DEVELOPMENT REVIEW BOARD
TRANSPORTATION DEVELOPMENT

DRB Project Number: 1008585
Avalon Subdivision-
Utility Trailer Sales

SUBJECT: EPC Approved Site Plan for Building Permit

Application #: 18DRB-70113 (18EPC-40004)

BUILDING ELEVATIONS

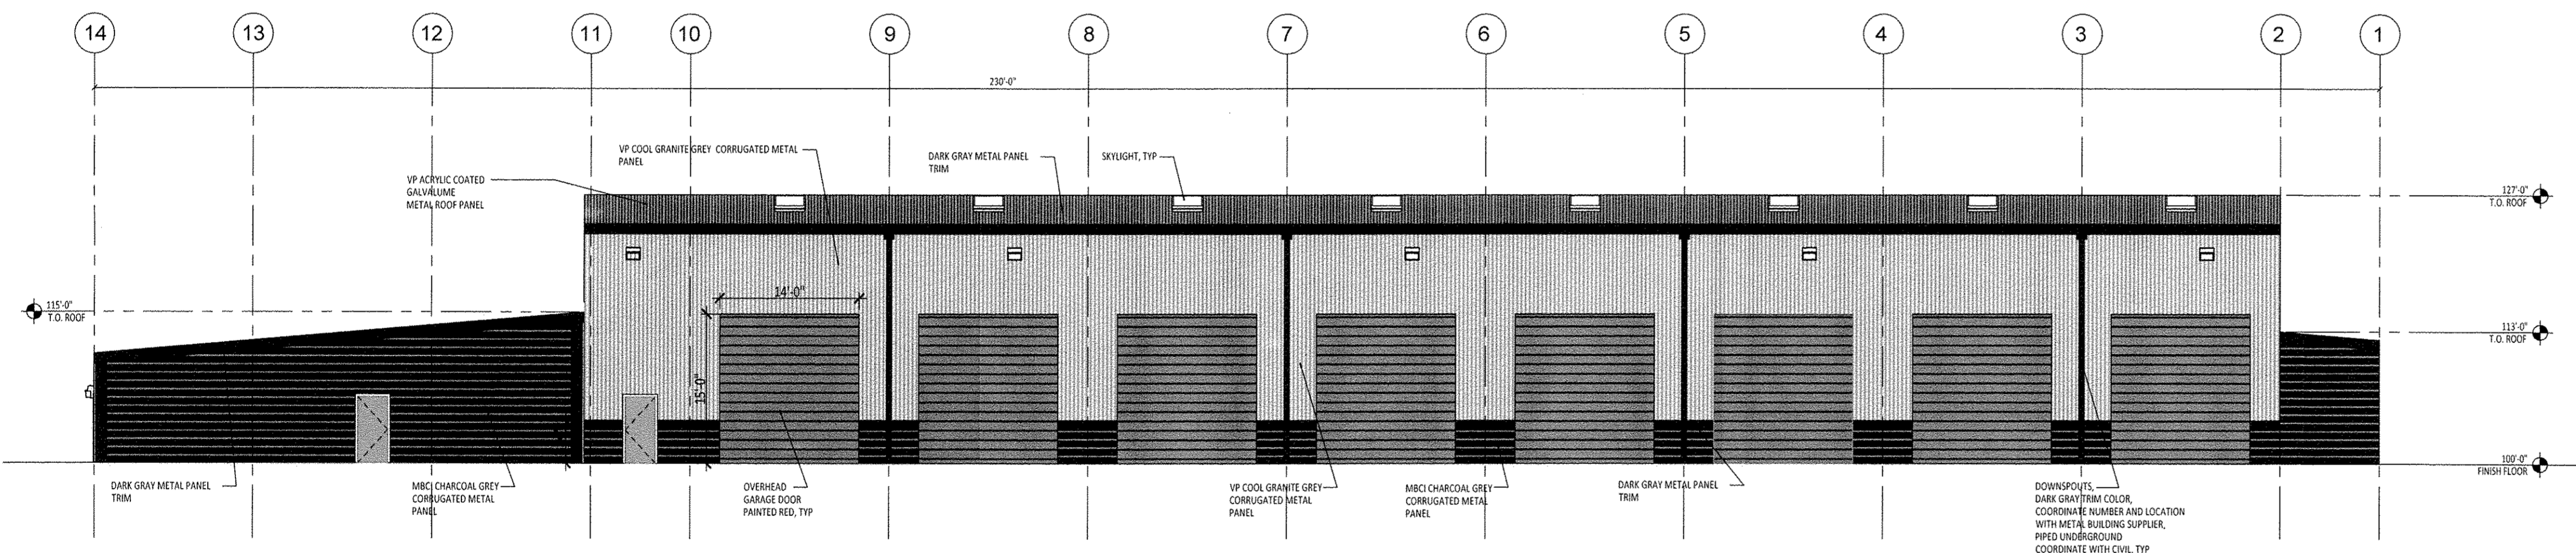
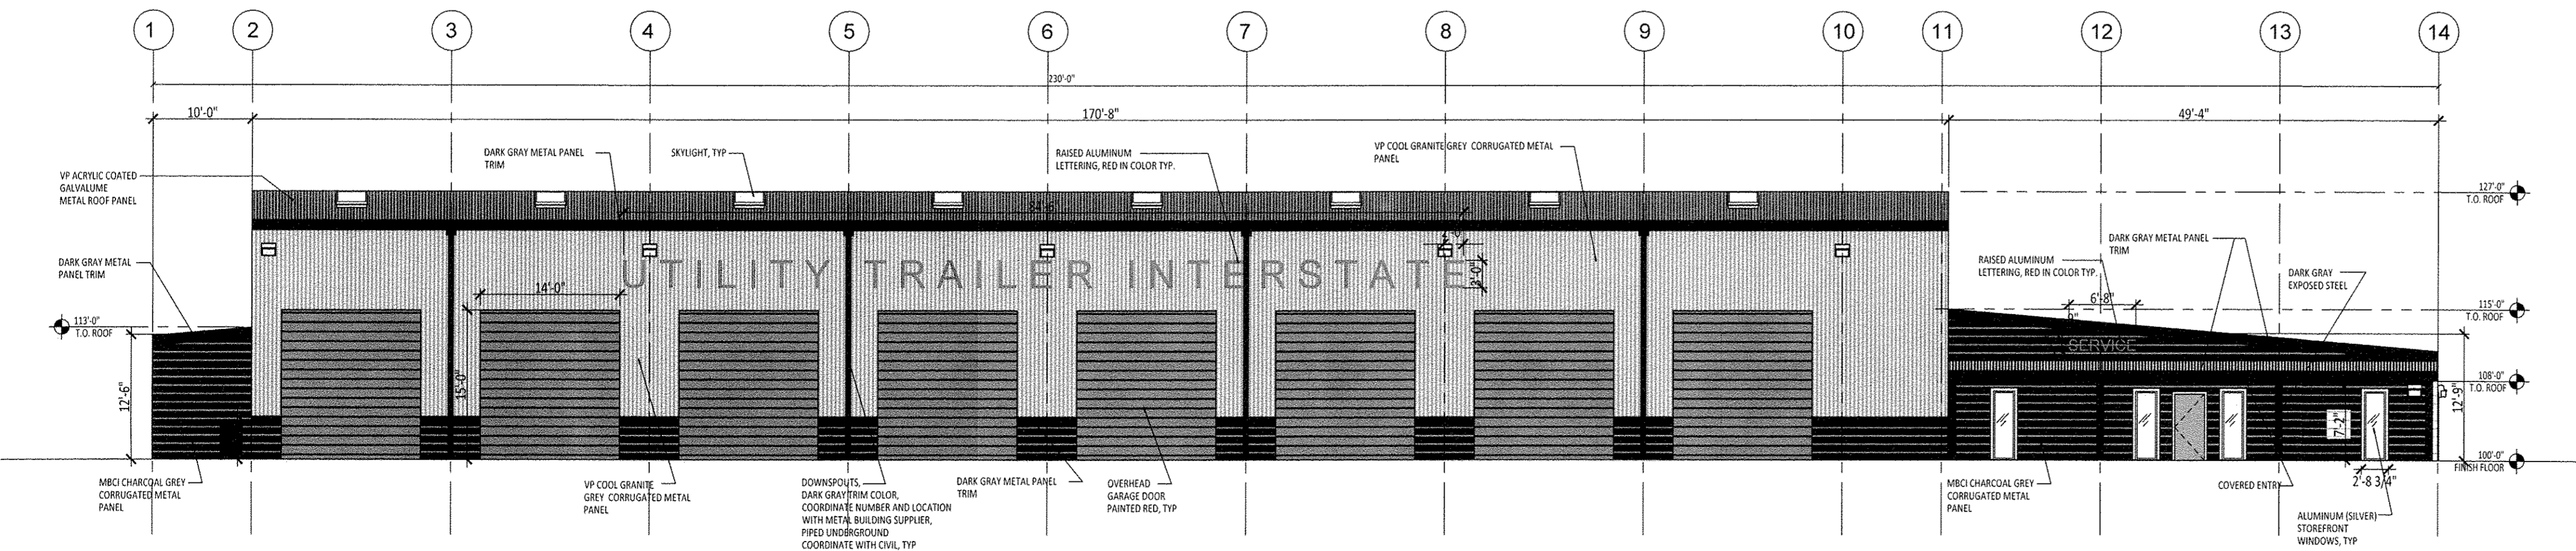
1. Condition 3 requires outdoor seating which has been added, however, there seems to be a conflict with the placement of the benches and the windows as shown on the elevations, so they should coordinate the plans with the elevations. Also, I am assuming the hatching on the sidewalk means the seating is covered, however, this should be on the legend to be clear.
ADDRESSED

UTILITY TRAILER SALES ALBUQUERQUE NM	DRAWN BY LA
	DETAIL SHEET 02	DATE 03/20/2018
		2017041_SPE 3
		SHEET # C6
RONALD R. BOHANNAN P.E. #7868	TIERRA WEST, LLC 5571 MIDWAY PARK PLACE NE ALBUQUERQUE, NM 87109 (505) 858-3100 www.tierrawestllc.com	JOB # 2017041

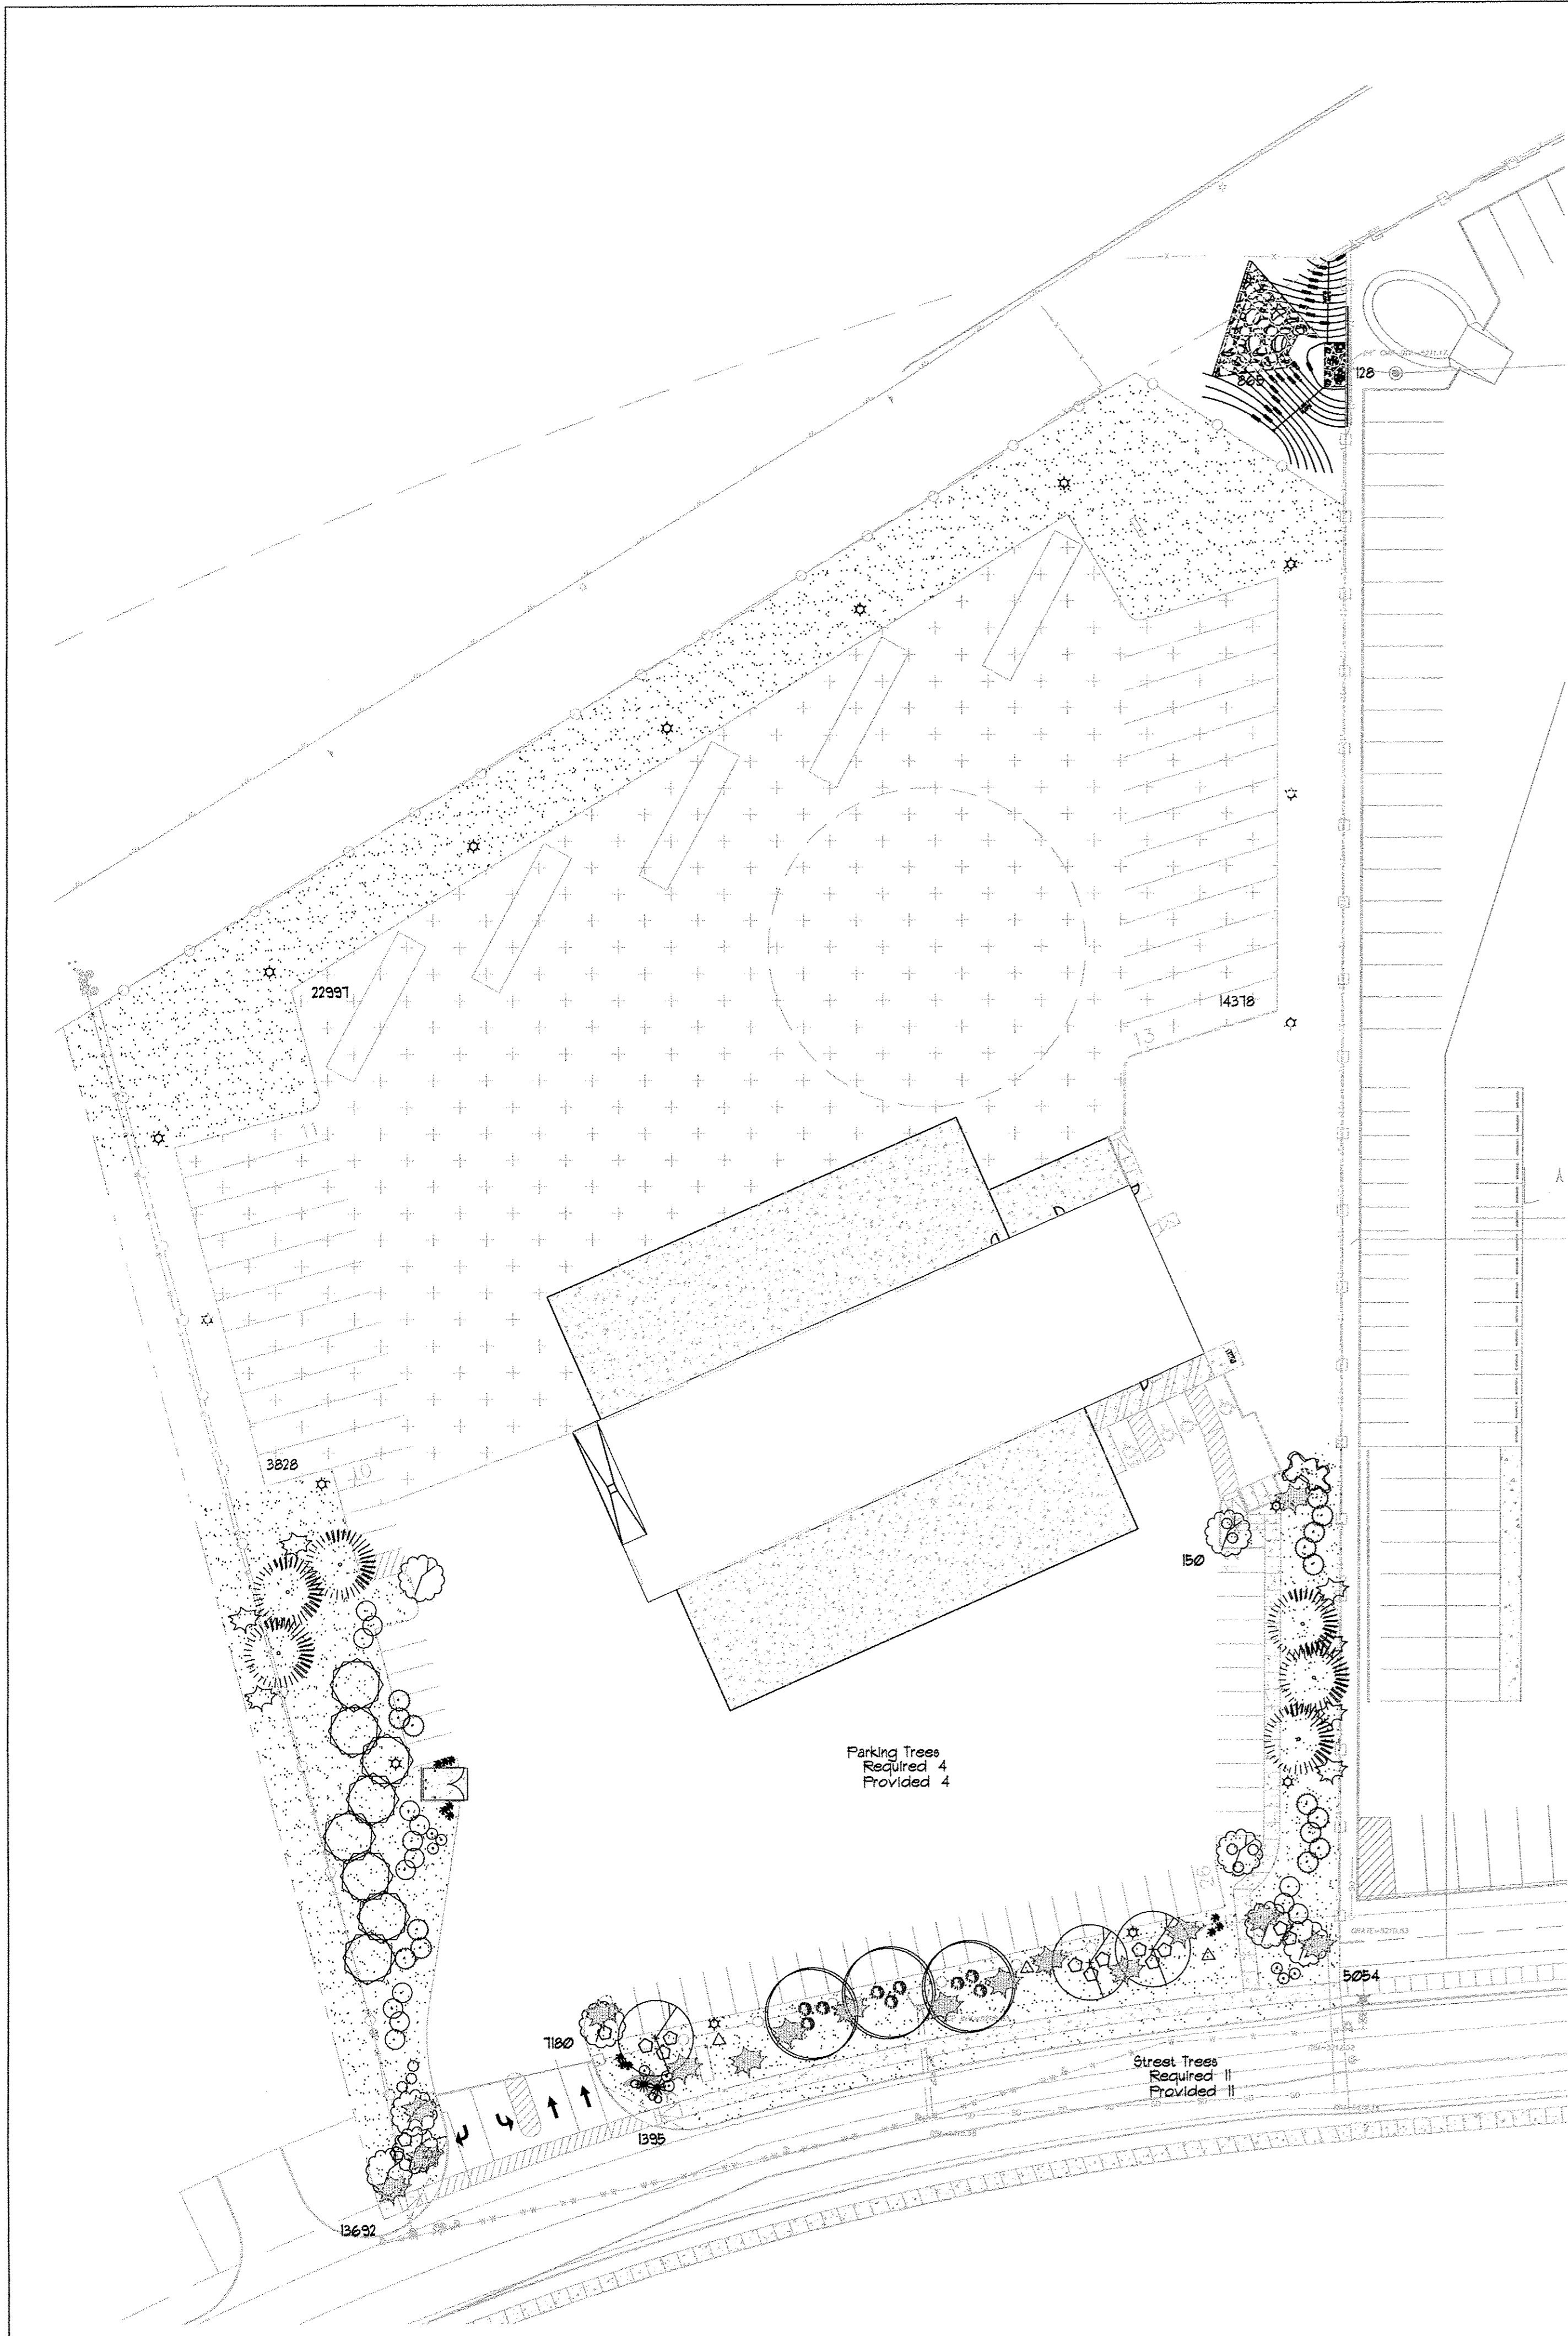
1. Show actual existing roadway conditions to the east of the site.
2. Provide a public roadway easement or public right of way for the turnaround.
3. Change size of item #1 on the infrastructure list to - 24' F-Edge
4. Please add the clear sight triangle to each subdivision entrance. Add the following note as well: "Landscaping, fencing and signing will not interfere with clear sight requirements. Therefore, signs, walls, trees, and shrubbery between 3 and 8 feet tall (as measured from the gutter pan) will not be acceptable in the clear sight triangle."
5. Please add a note on the plan stating "All improvements located in the Right of Way must be included on a public work order."
6. Monument sign should be added to the landscape plan.

2. Condition 9 requires compliance with the zoning code except as specifically approved by the EPC, and signs are subject to the underlying C-2 zone, Section 14-16-2-17 (10) (c)). Since Daytona is a collector, the free-standing sign area shall not exceed 100 square feet, and 118 square feet is being shown. Also, because there is a free-standing sign on Daytona, the building mounted sign will be limited to 12.5% of the dimension of the elevation, so the applicant should show the dimensions of the façade and the building mounted sign. ADDRESSED
